Final Report - Corrections Required **Application No. ANEX-24-0007**

Description : Matrix Design Group on behalf of Colorado Springs Equities LLC is submitting a serial annexation petition for seven parcels and Land Use Plan/Rezoning exhibit for a portion of the subdivision known as Rock Creek Mesa.

Document Filename : Rock Creek Mesa Addition 6_Petition_V3_5-13-24

ROCK CREEK MESA ADDITION NO. 6

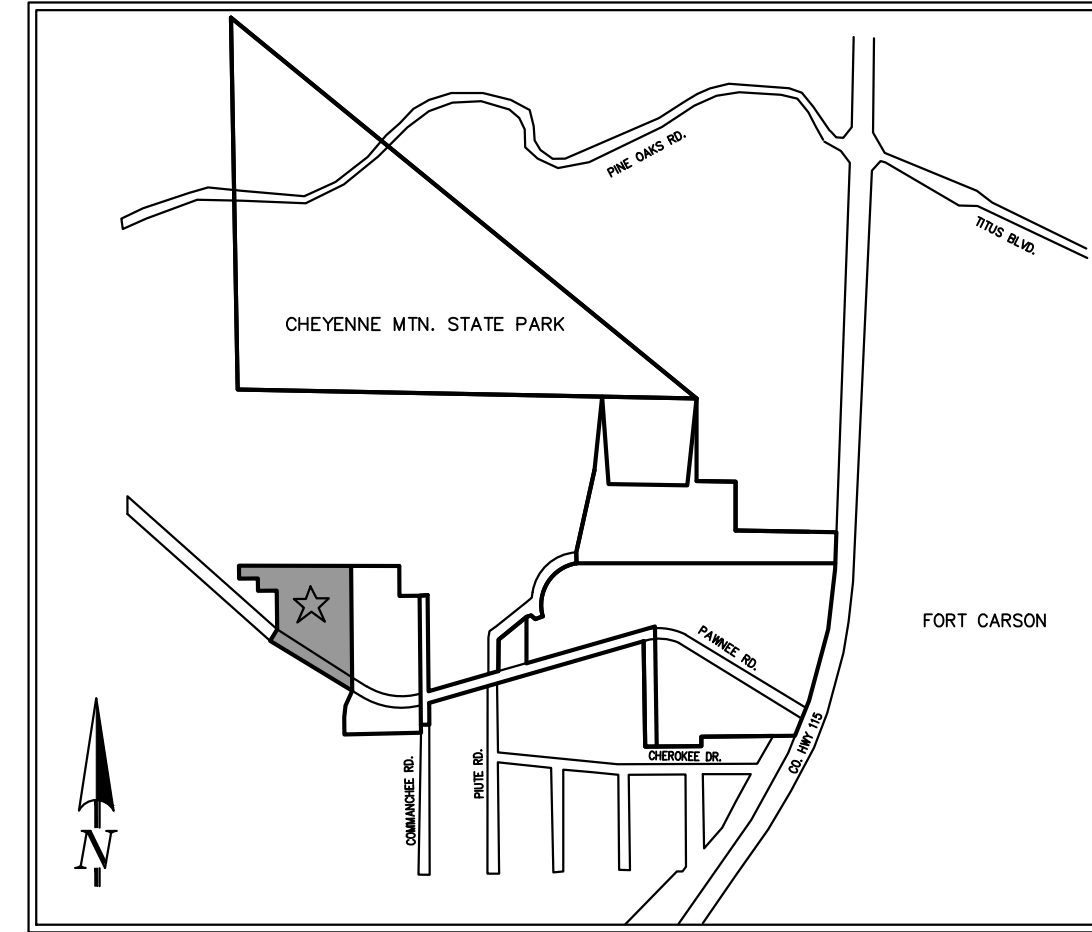
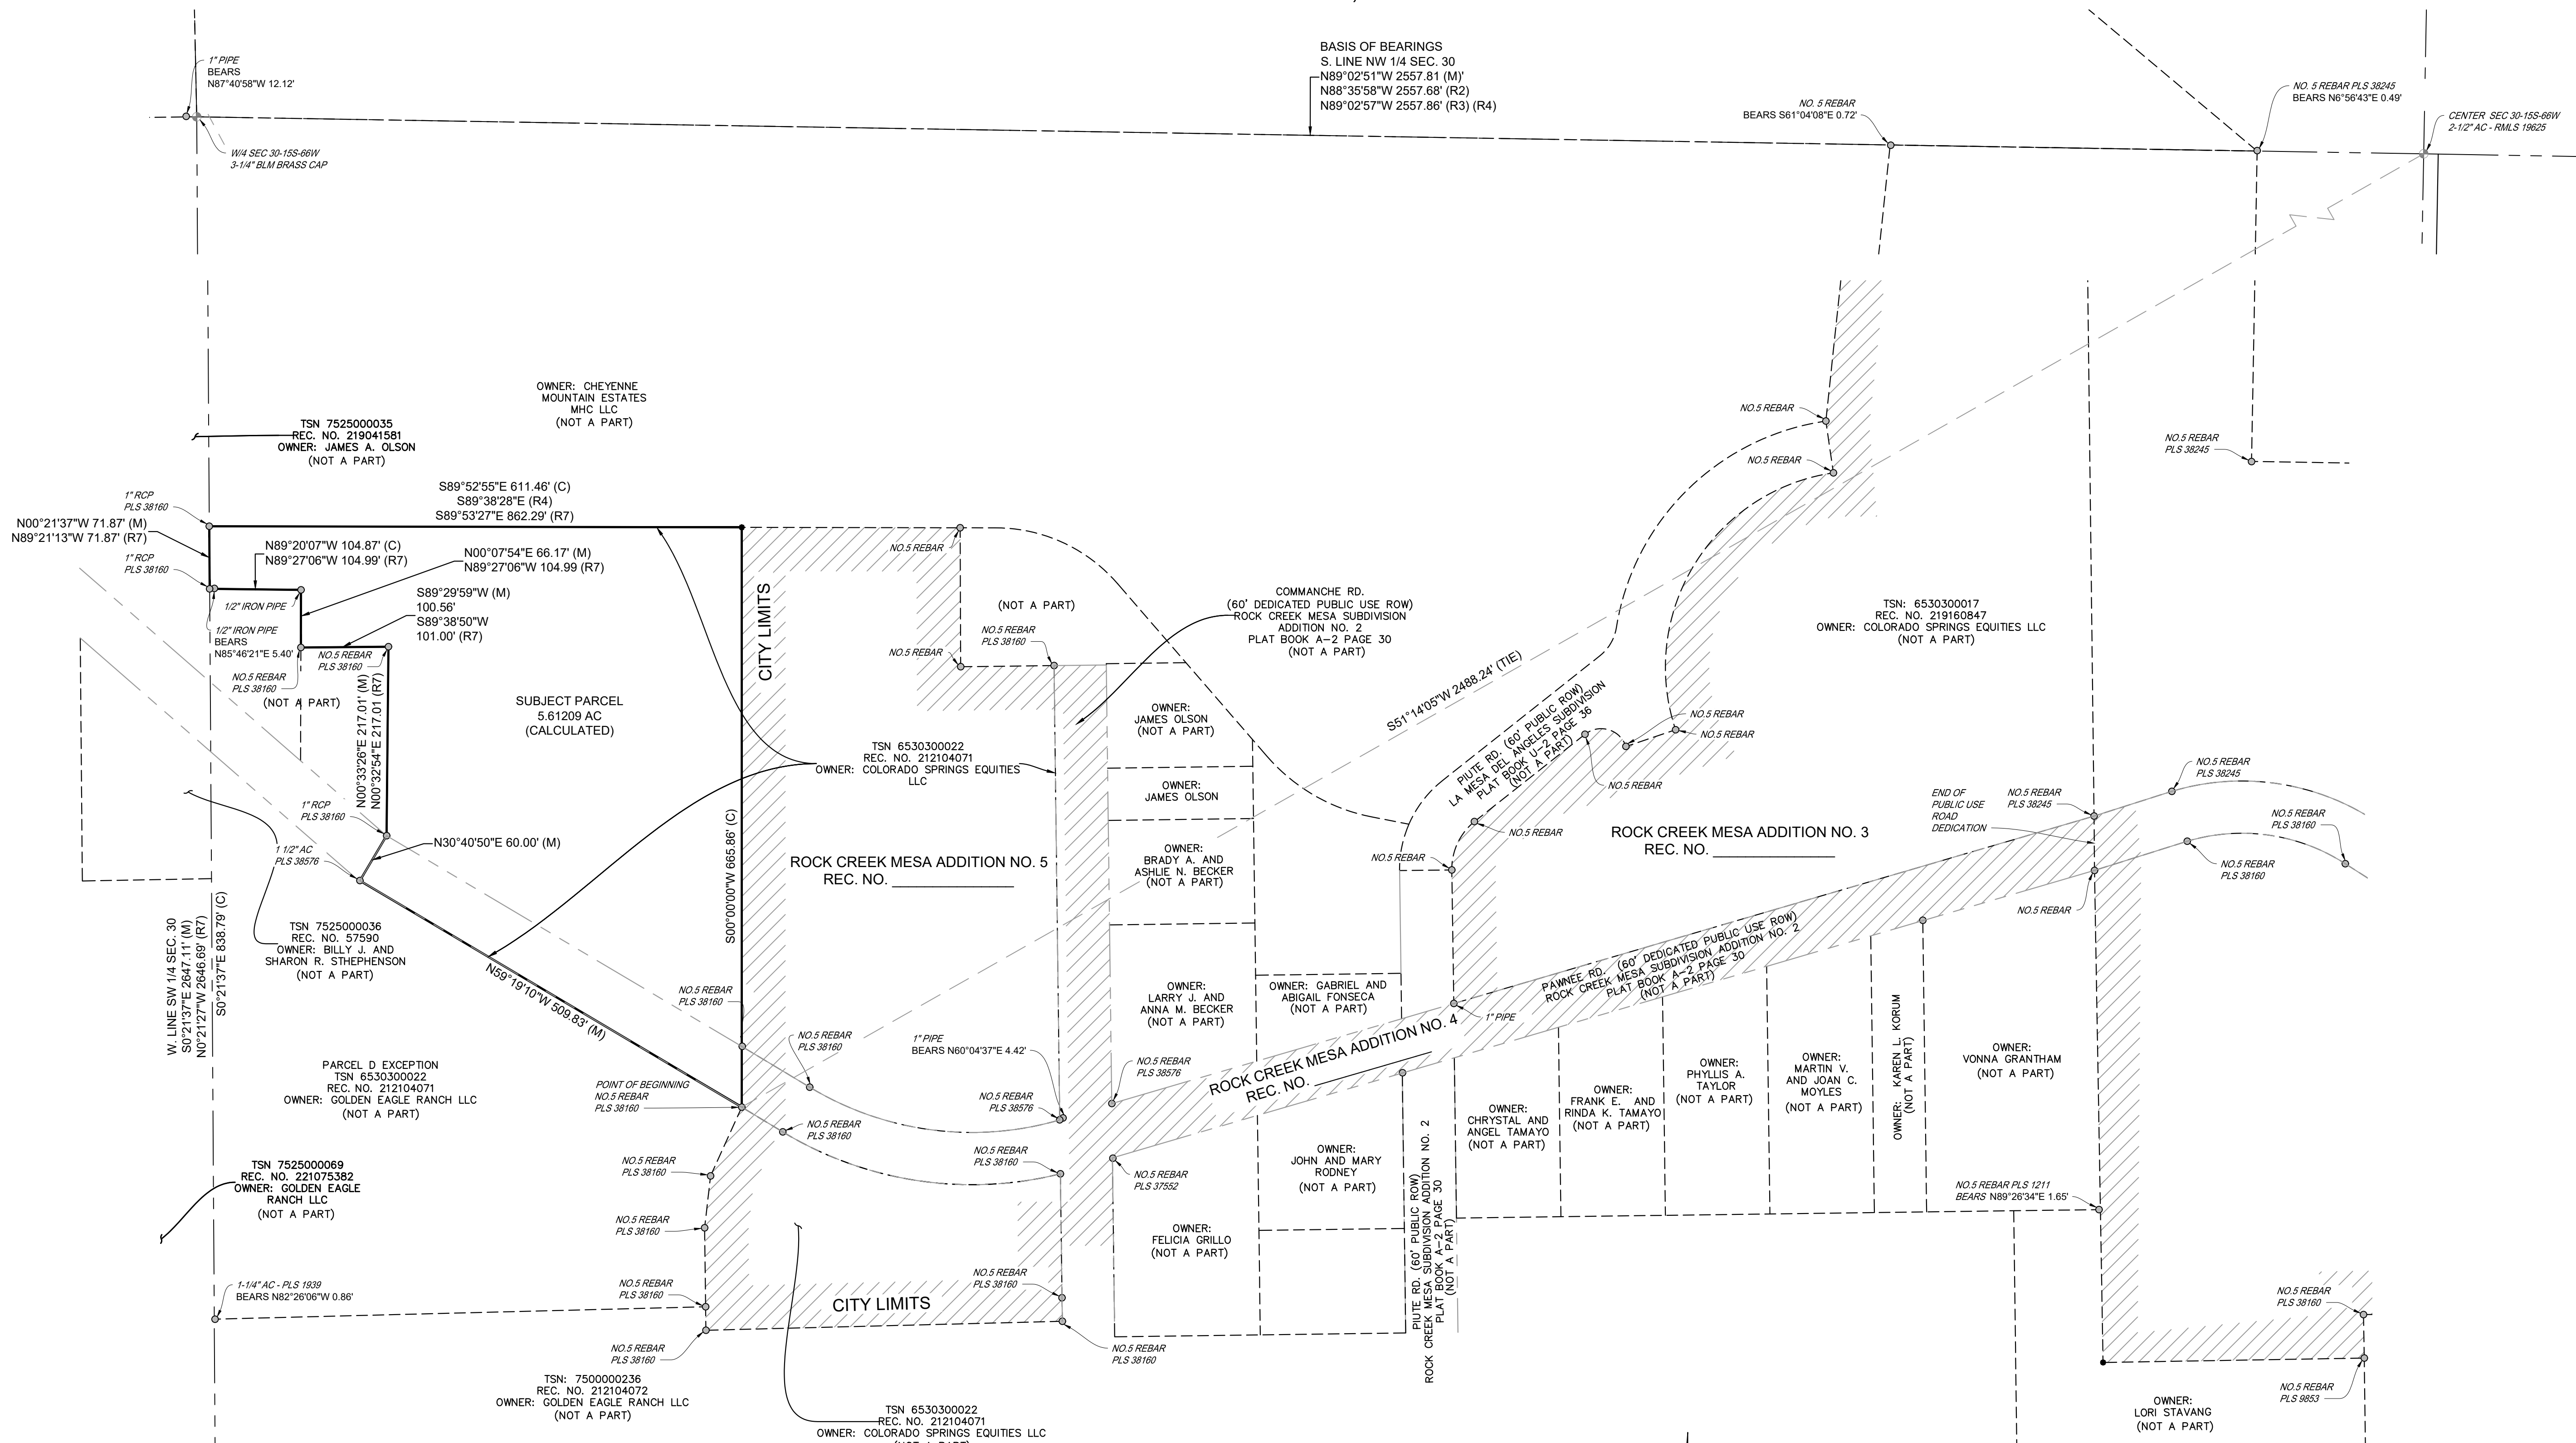
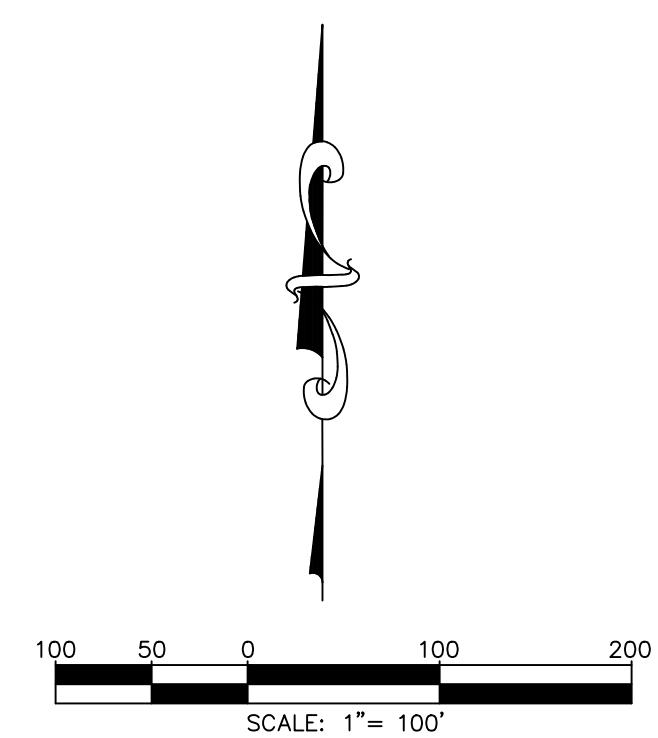
Comment ID	Page Reference	Reviewer : Department	Review Comments
48	1	Gabe Sevigny : Planning	update legal description per Surveyor comments
